**Project: Fenwick Solar Farm (PINS Reference: EN010152)**  
**Our Reference: JEJ/ADW/124645.0023**

## Written summary of oral submissions made at the Issue Specific Hearing 1 on 20 March 2025

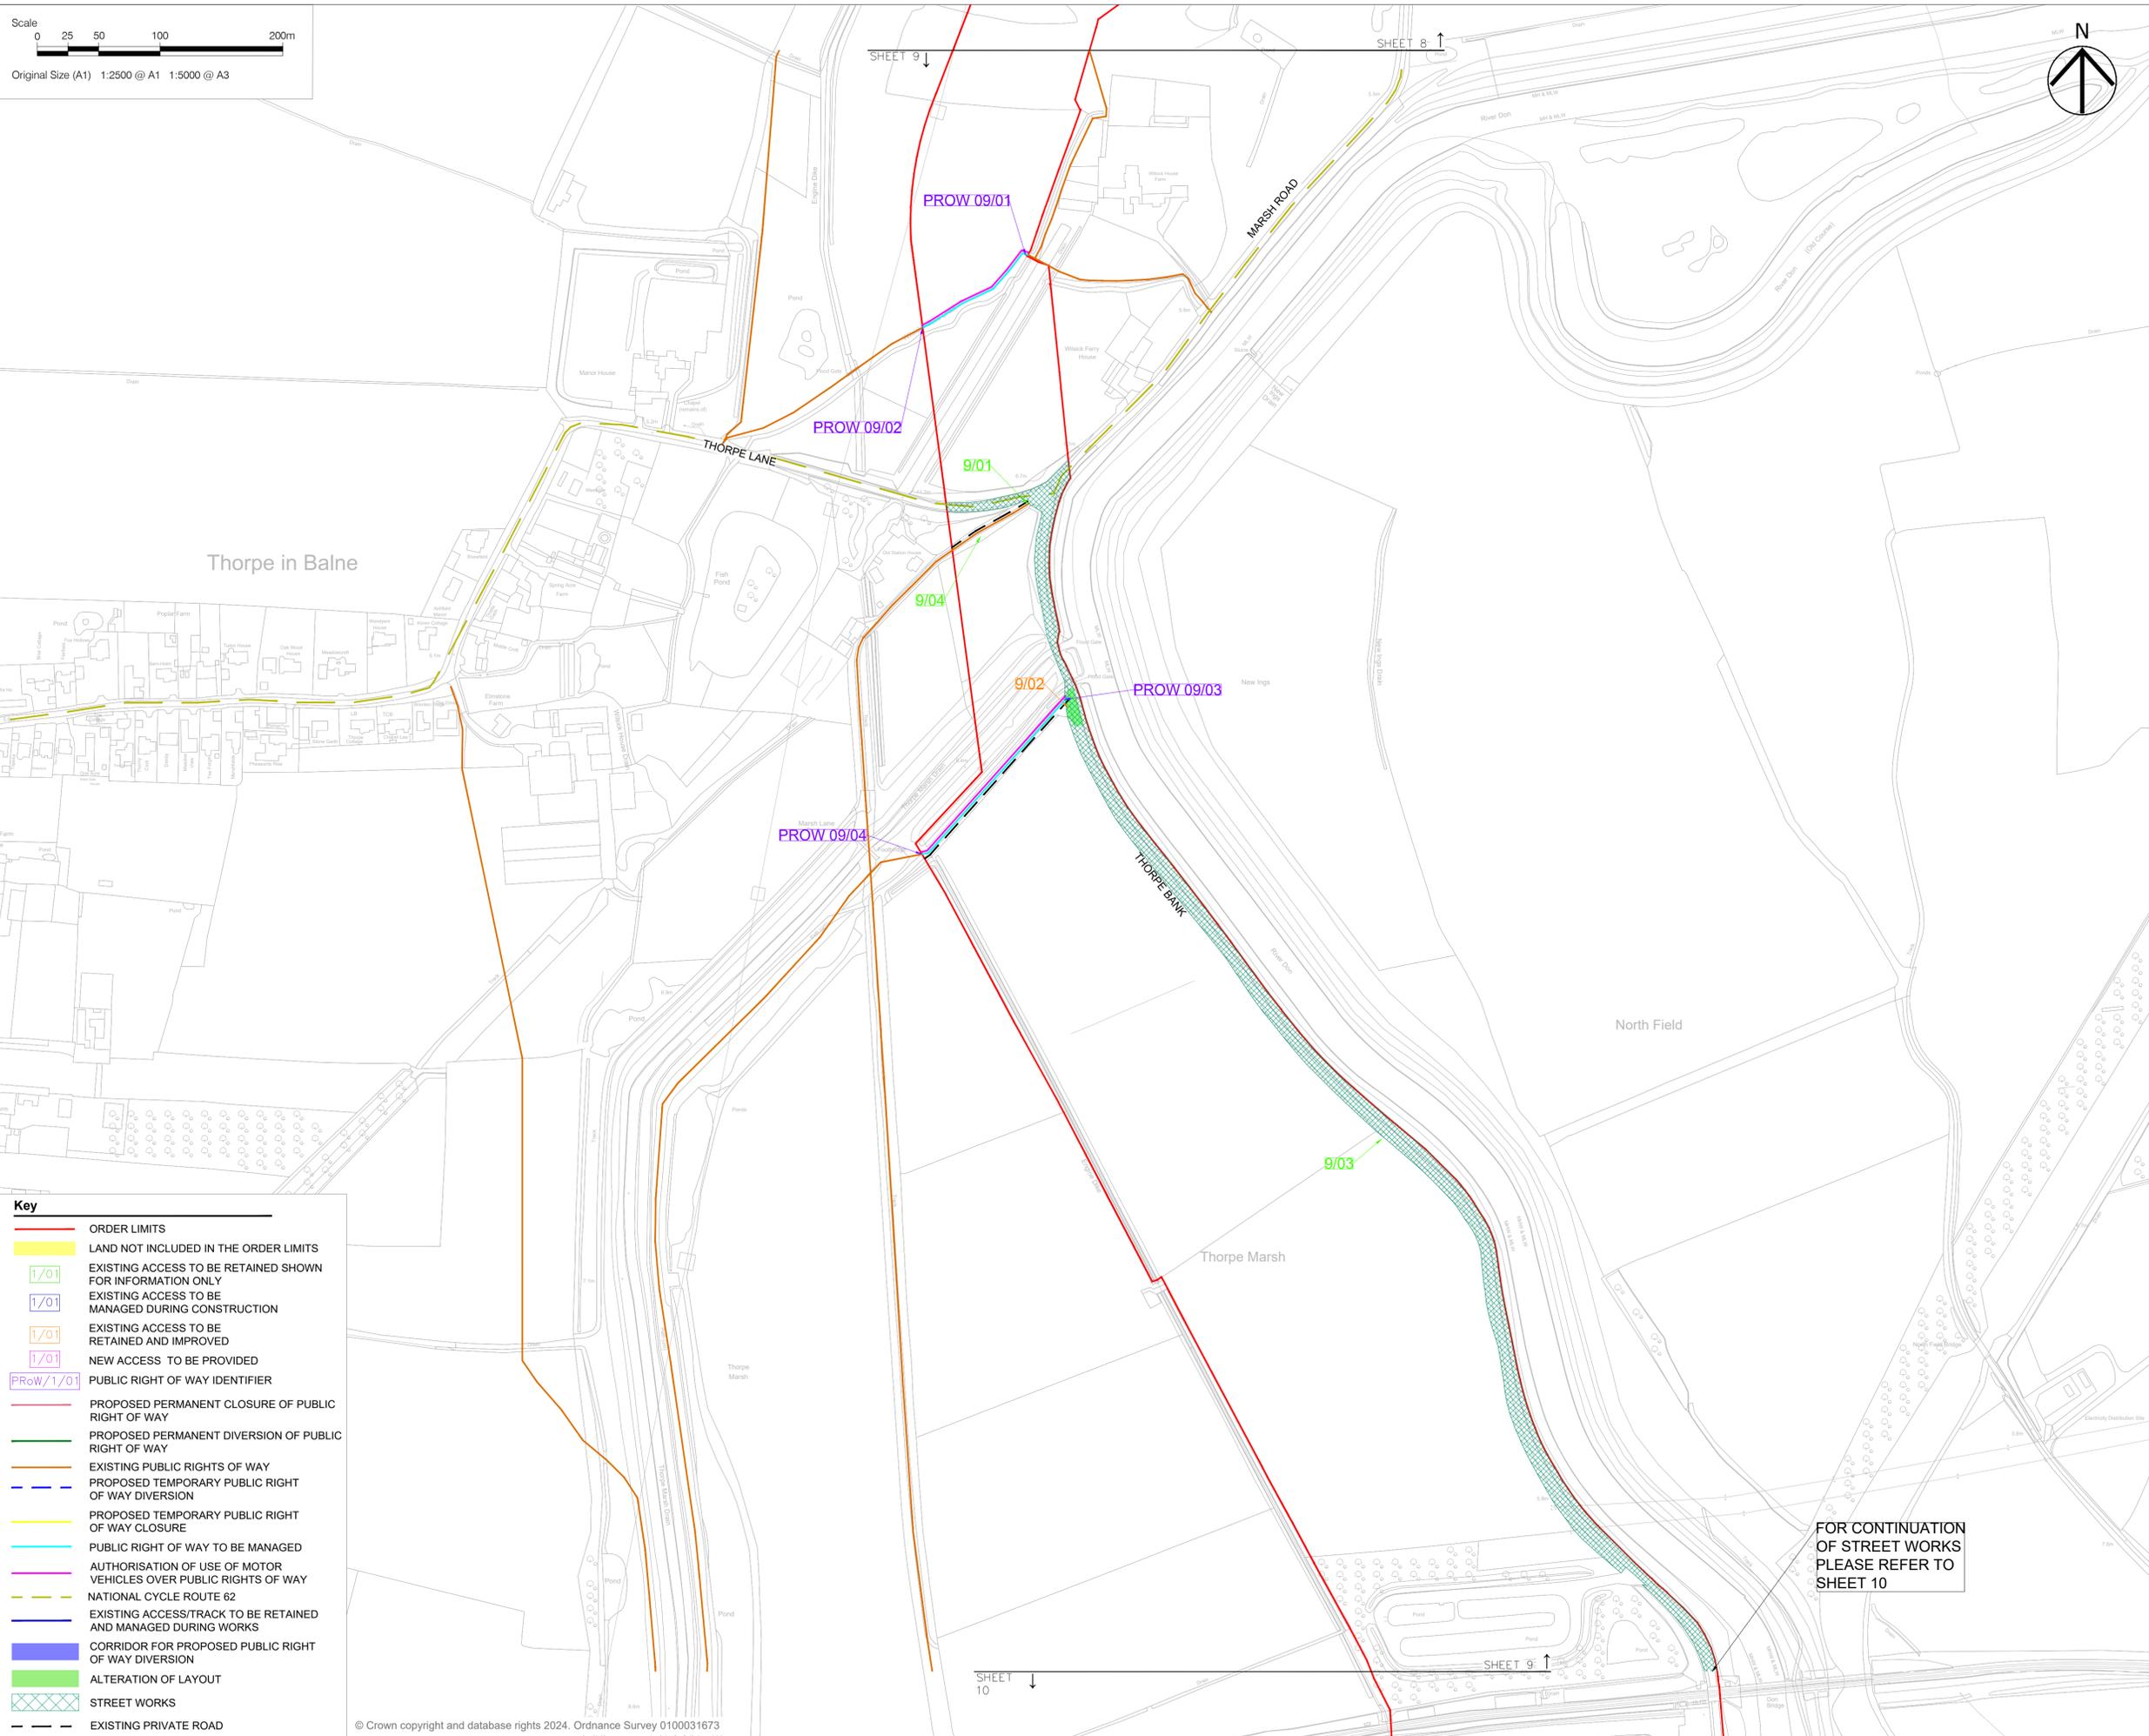
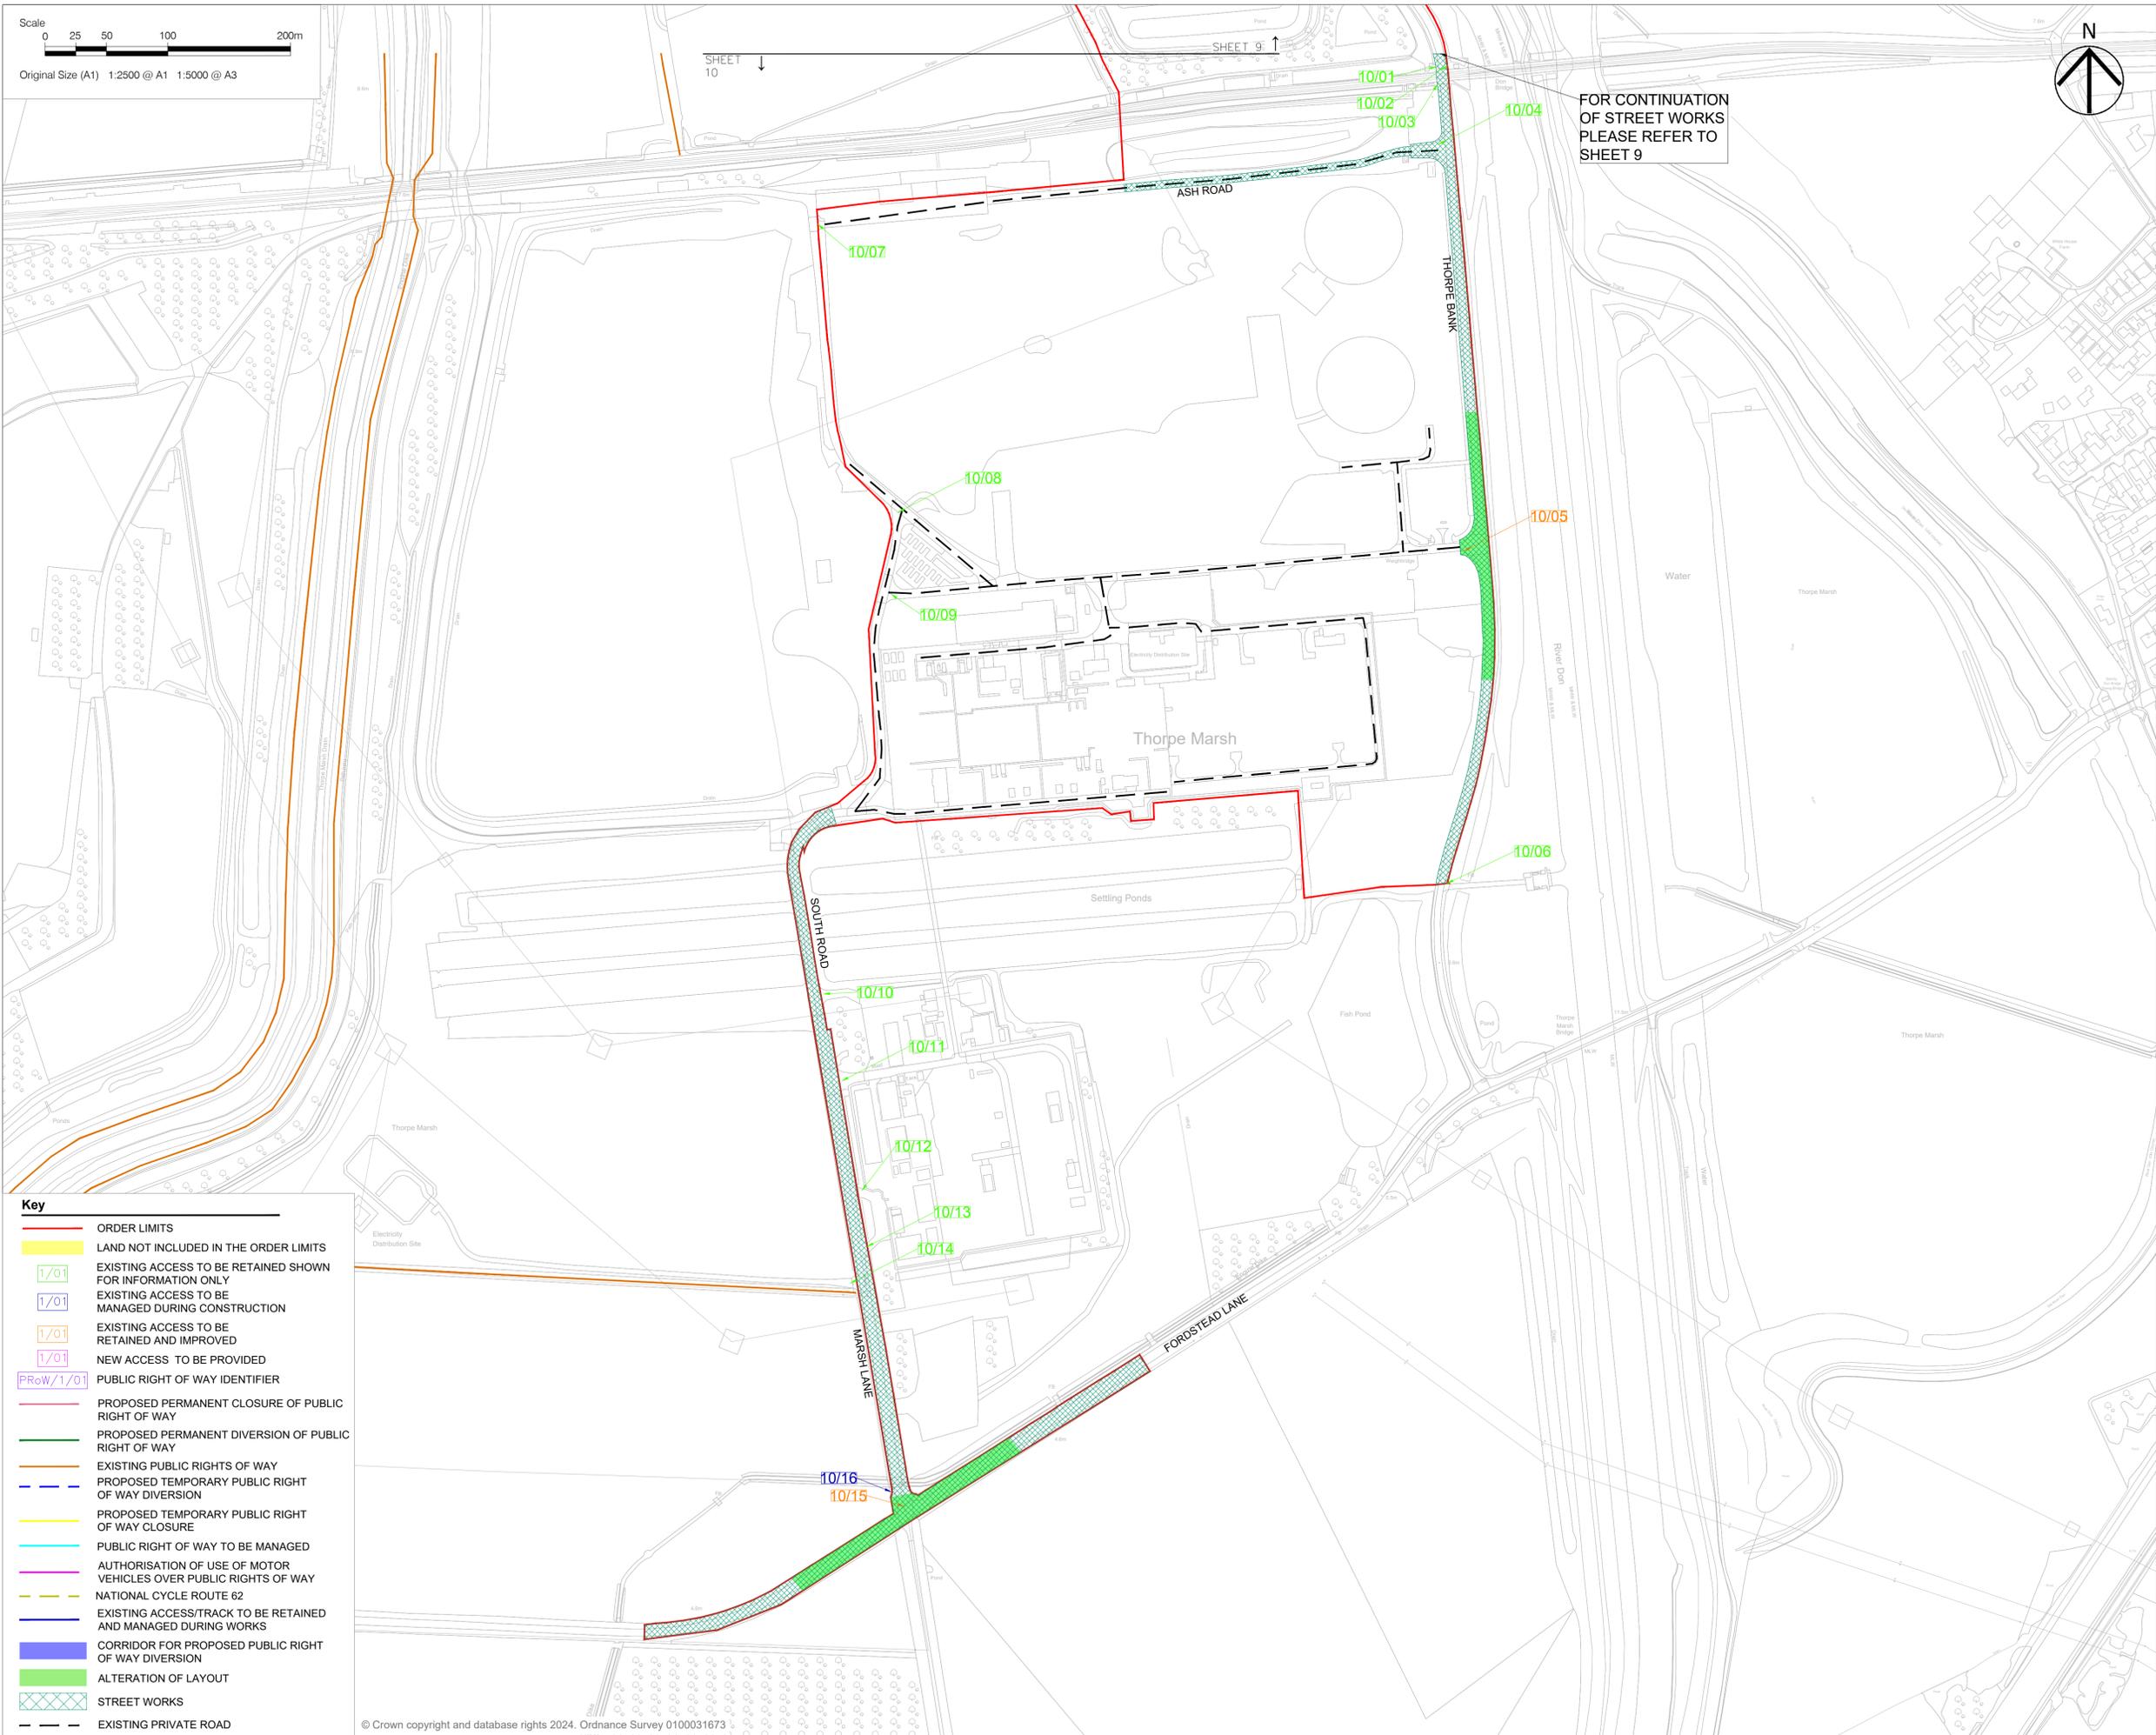
1.2 ABLE strongly object to the breadth of this provision, which would grant the undertaker sweeping and unjustified access to all private roads within the Order limits, including internal roads at ABLE's Thorpe Marsh site (indicated by dashed lines in sheets 9 and 10 of the Streets, Rights of Way and Access Plan ([APP-008](#))).

1.3 This request is wholly disproportionate and demonstrates the Applicant's failure to accurately assess the specific private roads it requires access to, let alone explore less disruptive alternatives. The reasonable and proportionate approach would be to limit the undertaker's access to the area marked hatched green on sheet 10 of the Streets, Rights of Way and Access Plan ([APP-008](#)) to access Thorpe Bank for the purposes of laying cables. In short, ABLE maintains that the Applicant should limit their access over ABLE's land to a maximum of one road, or preferably none if feasible alternatives exist.

1.4 To this extent, the Applicant should reconsider Article 13 and the relevant plans to identify how it can limit its powers of access over private roads within the Order limits. ABLE propose that protective provisions provide the appropriate legal protection to properly secure ABLE's rights in controlling and regulating the undertaker's access over ABLE's private roads. Indeed, the ExA shared ABLE's concern and suggested that the Applicant included a separate schedule which expressly set out the individual private road(s) to be caught by Article 13.
